SUBJECT: BRES2301-0075
BUILDING RESIDENTIAL

Here are the results of all Inspections located at **1231 MURCHISONTOWN RD:**

Inspection Type: FOUNDATION
Scheduled Date/Time: 12/5/2024
Completed Date/Time: 12/5/2024
Inspector: Ricardo D Honrada
Result: DISAPPROVED
Remarks:

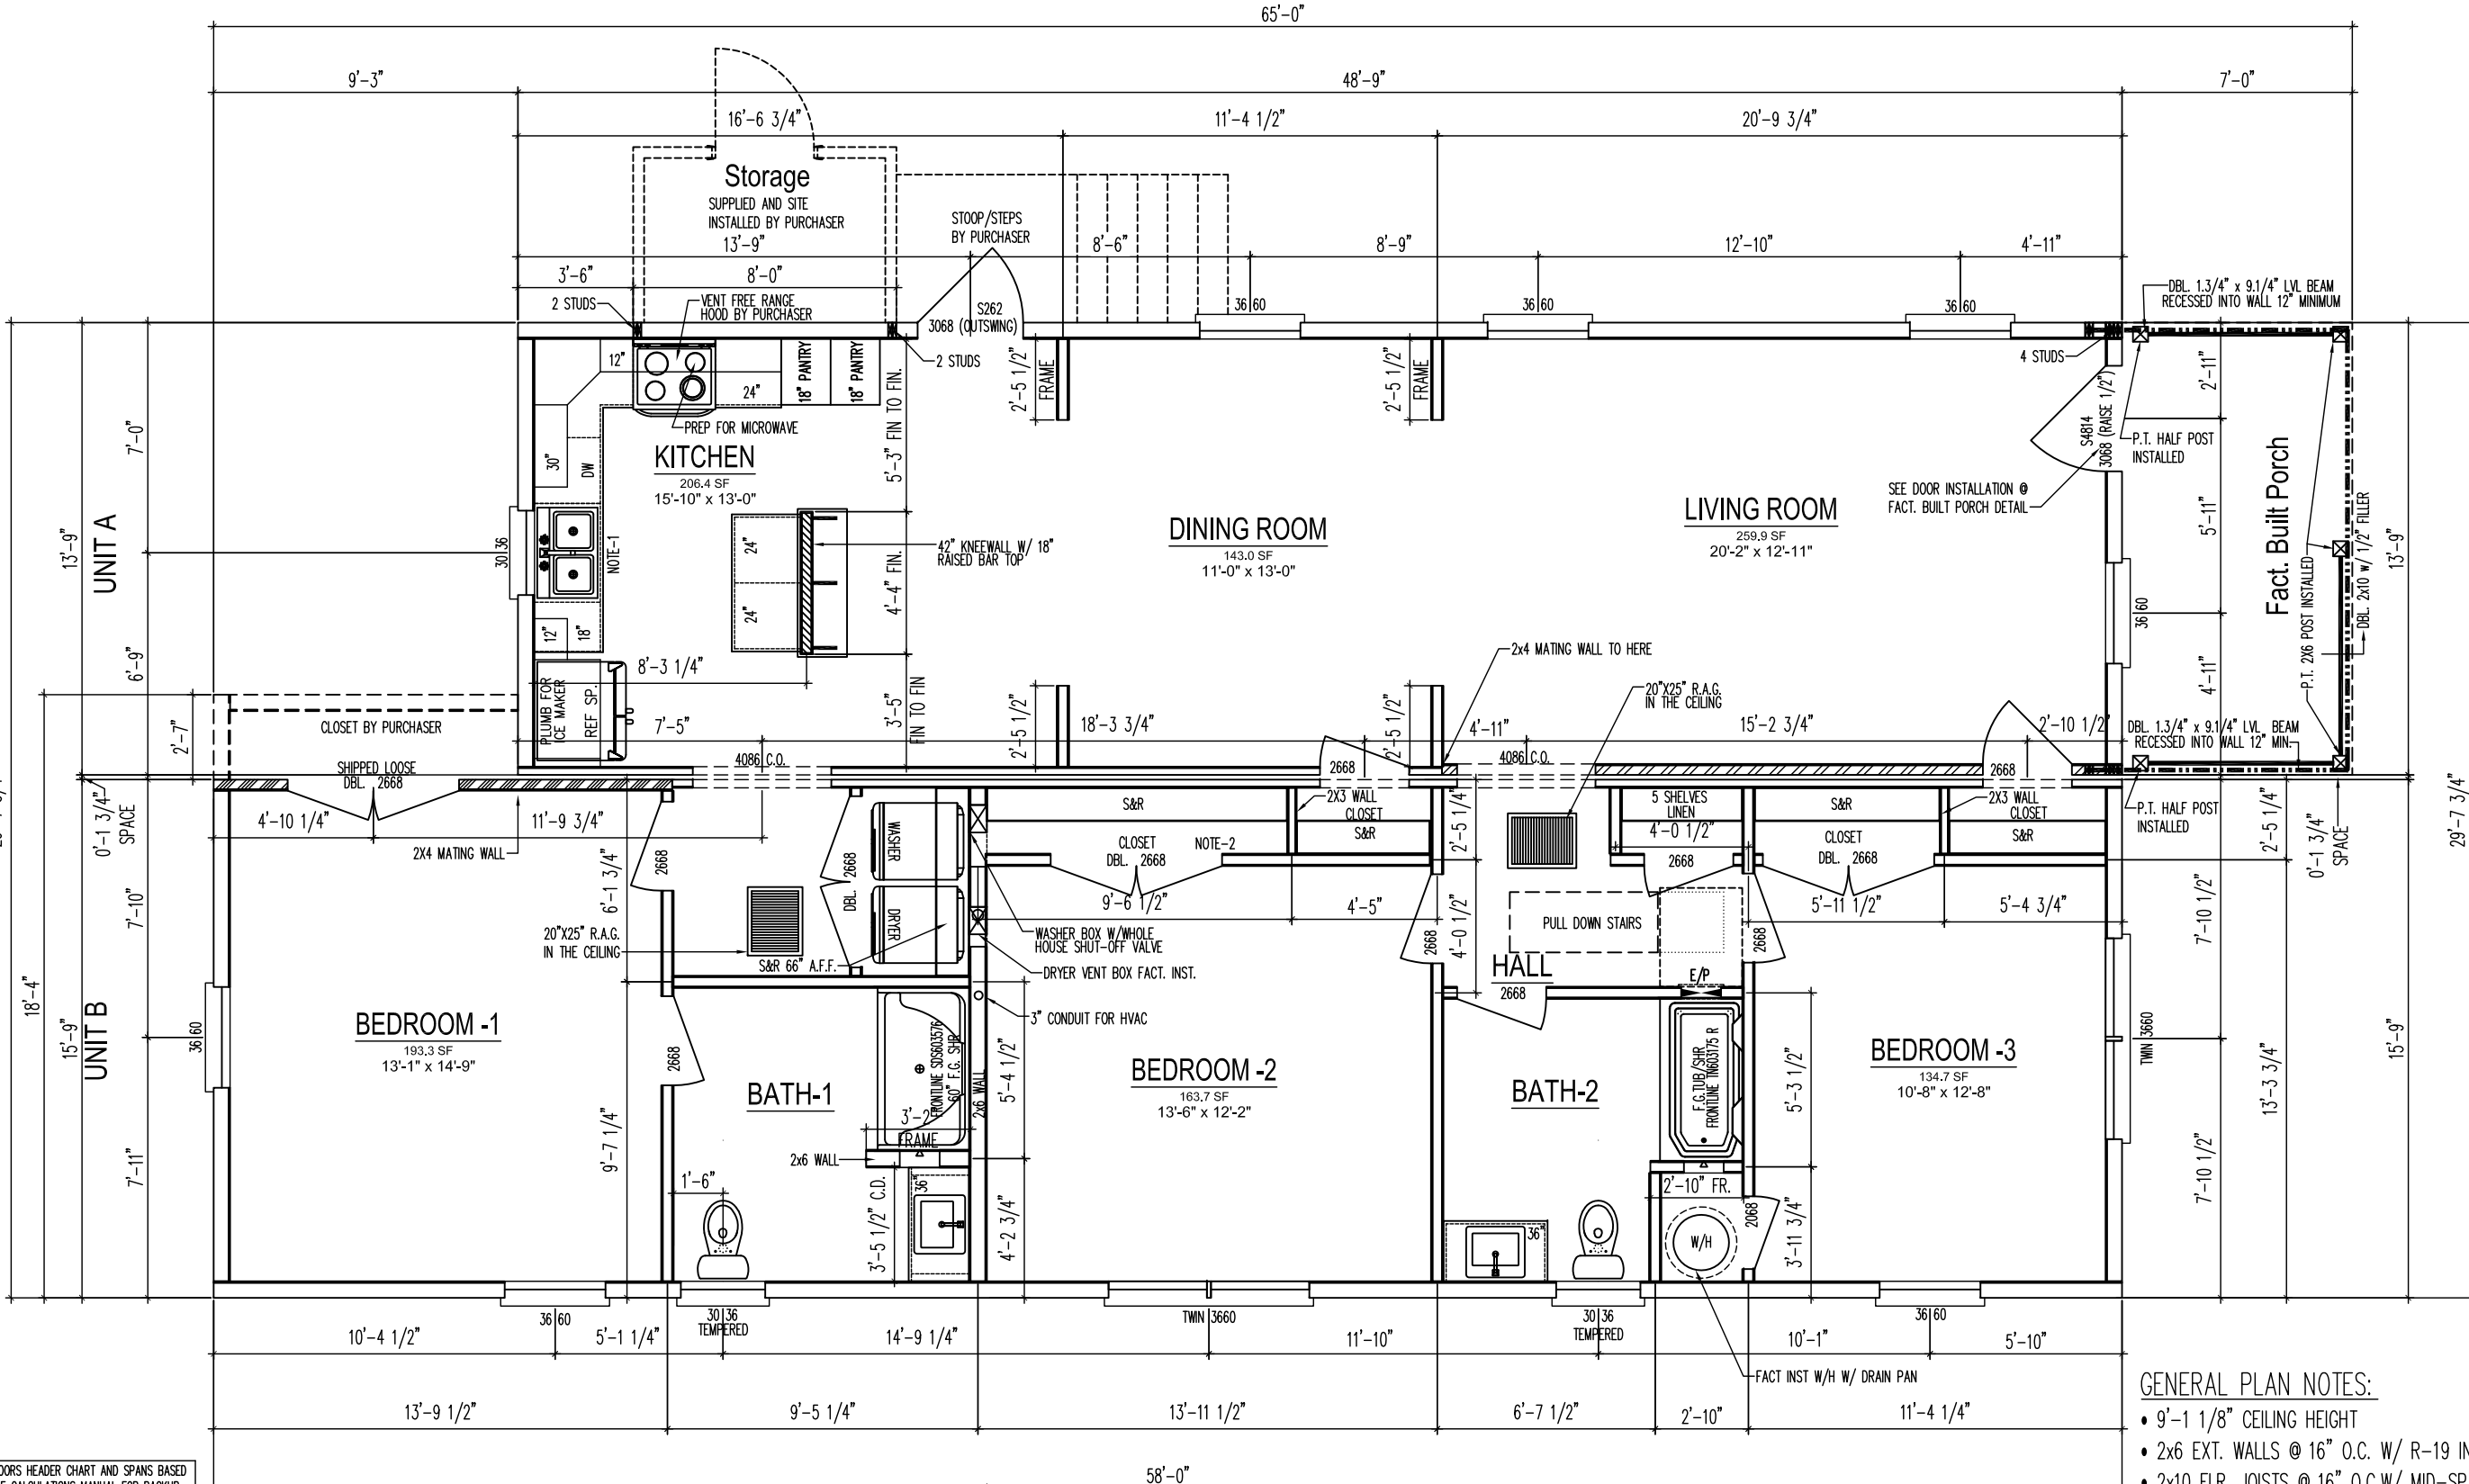
Notes: Uncover the top of walls footings and pier's columns, to see the projections. Need anchor bolts ref. Code R403.1.6
